# Rezoning Transportation Analysis

Petition Number: 2020-030

General Location Identifier: Tax ID 06706105

Date	Description
03-23-20	First Review
4/22/20	Second Review

SCHEMATIC
SITE PLAN

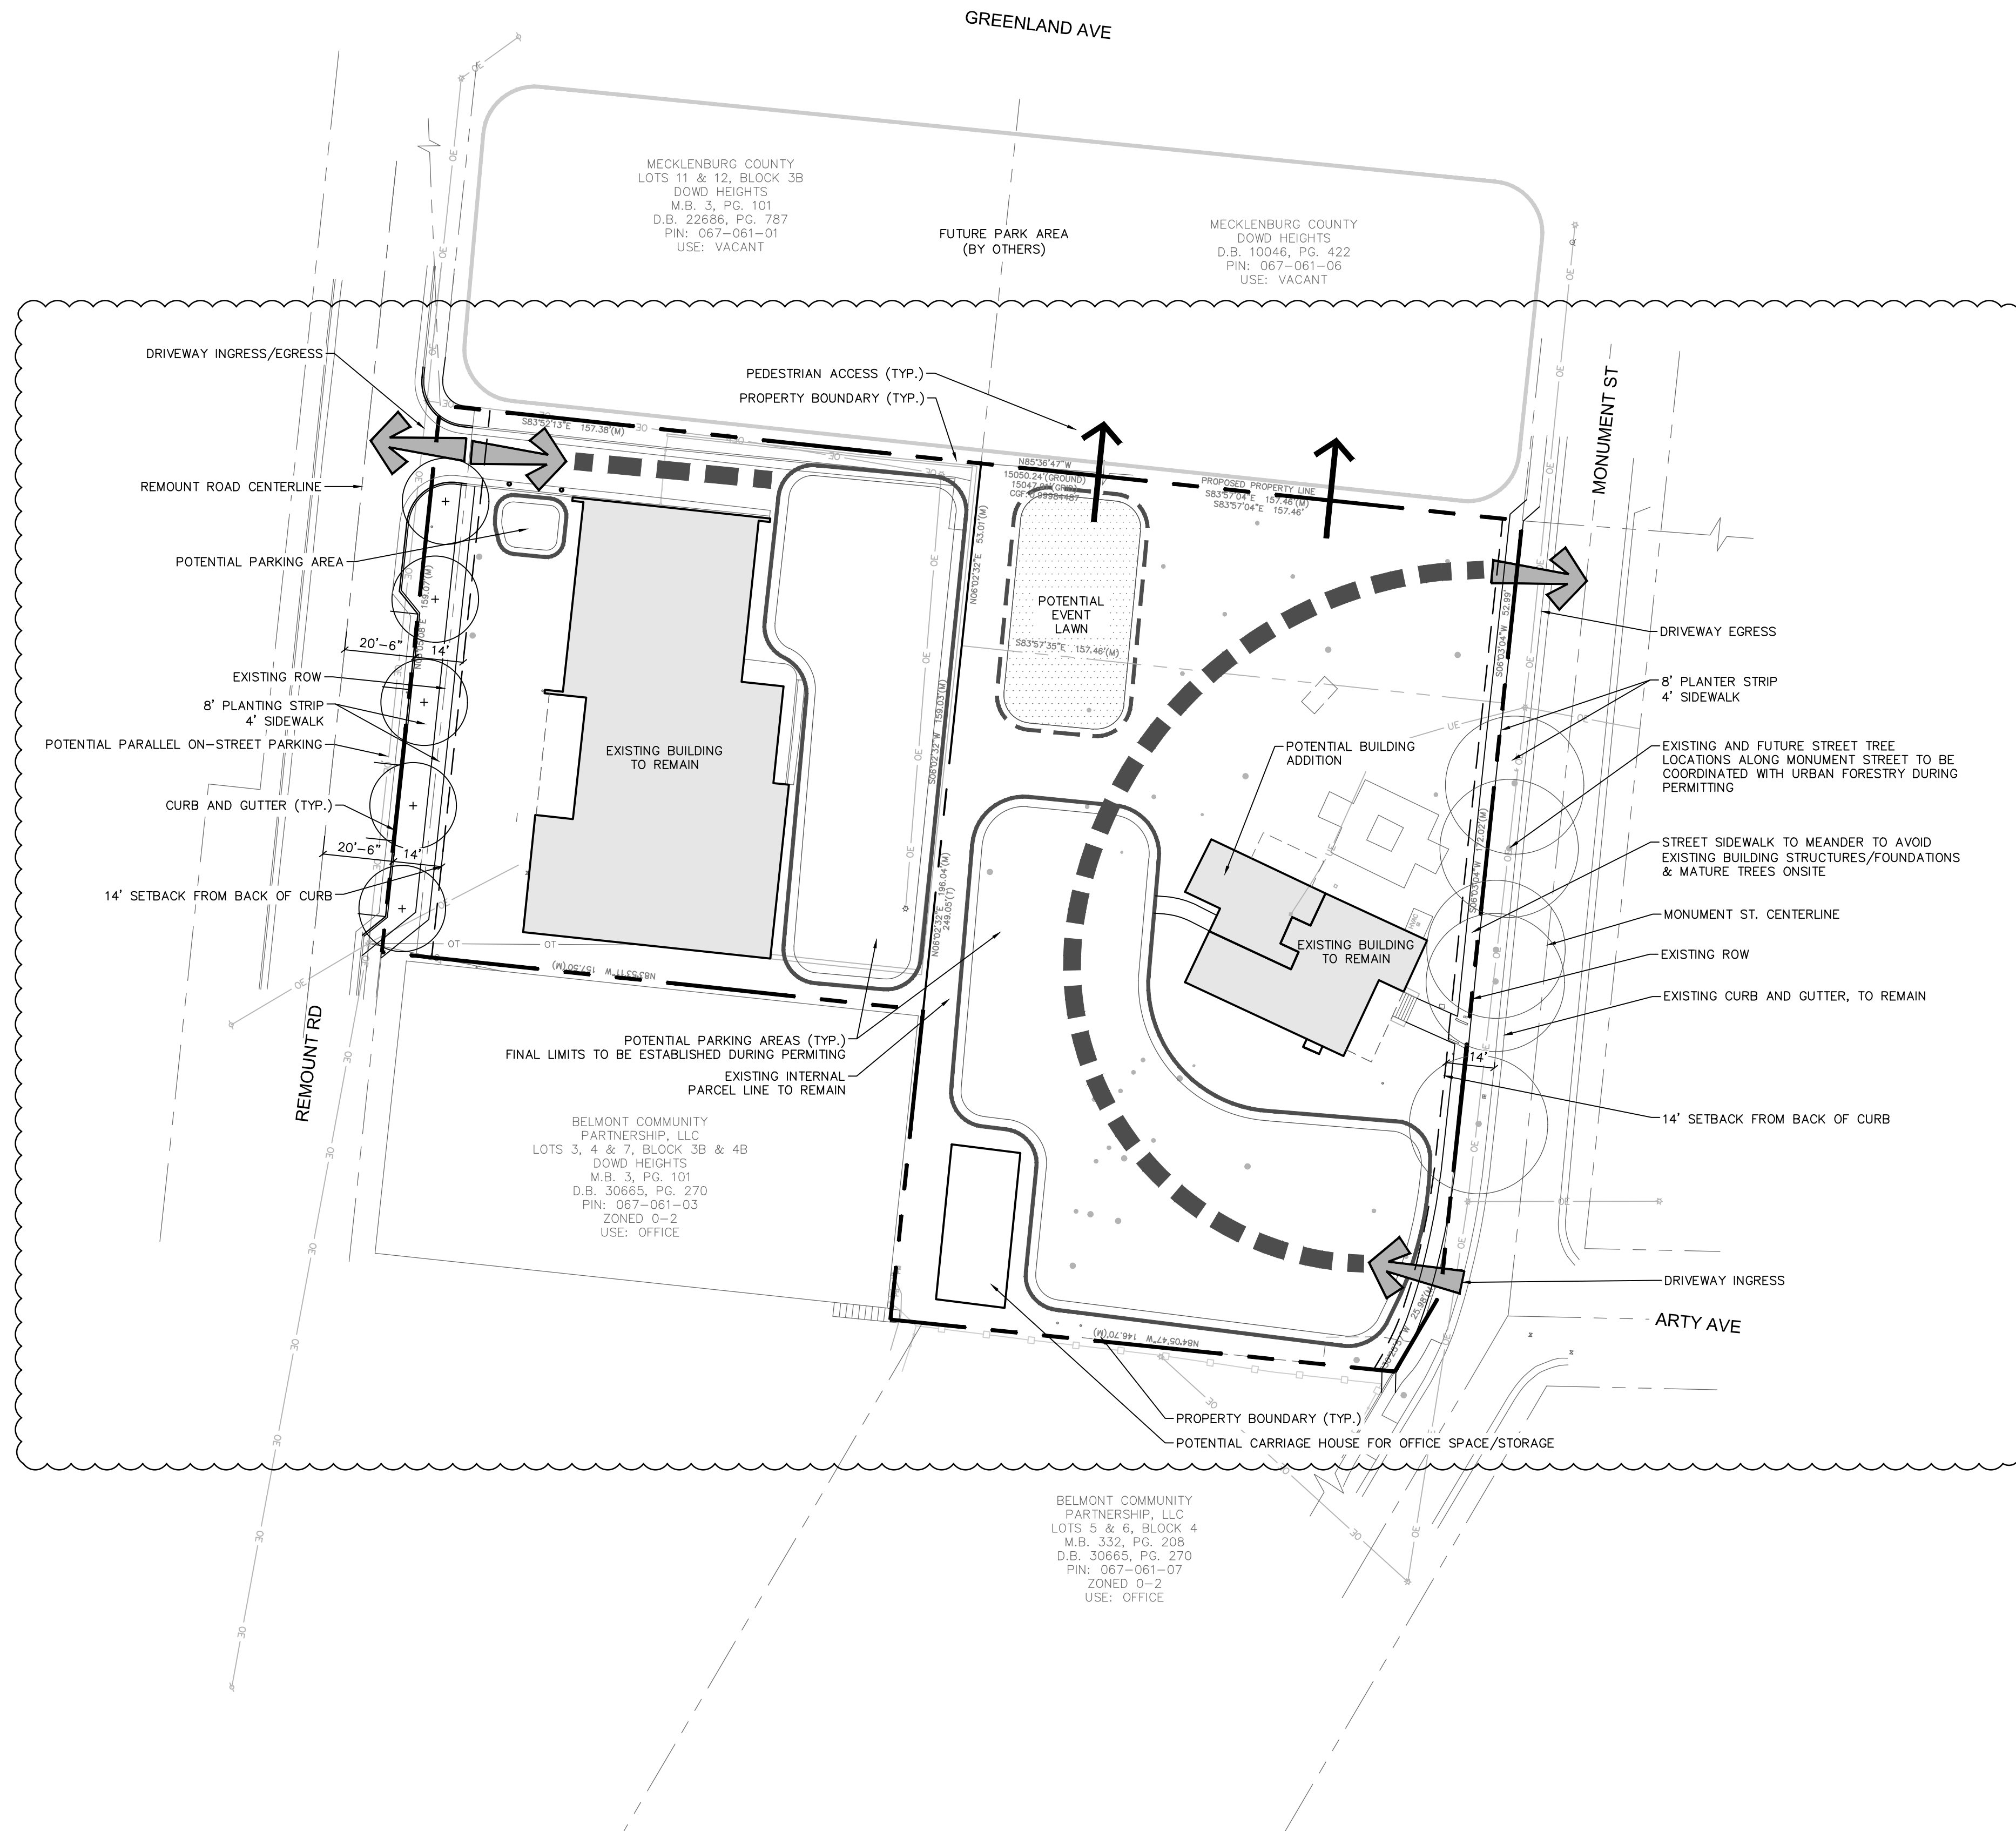
4. The petitioner should revise the site plan and conditional note(s) to commit to construct an 8-foot planting strip, and 6-foot sidewalk on Remount Road and Monument Street, per MUDD requirements as required within Chapter 9 of the Zoning Ordinance. The proposed sidewalk should meander behind the existing trees where feasible, located within a sidewalk utility easement if outside of the public right of way. If sidewalk may not be relocated behind the trees, sidewalk may be proposed to meander inside of the existing trees with a minimum of 7-foot back of curb sidewalk. The site plan should label and dimension both items from the back of curb and gutter and road centerline.
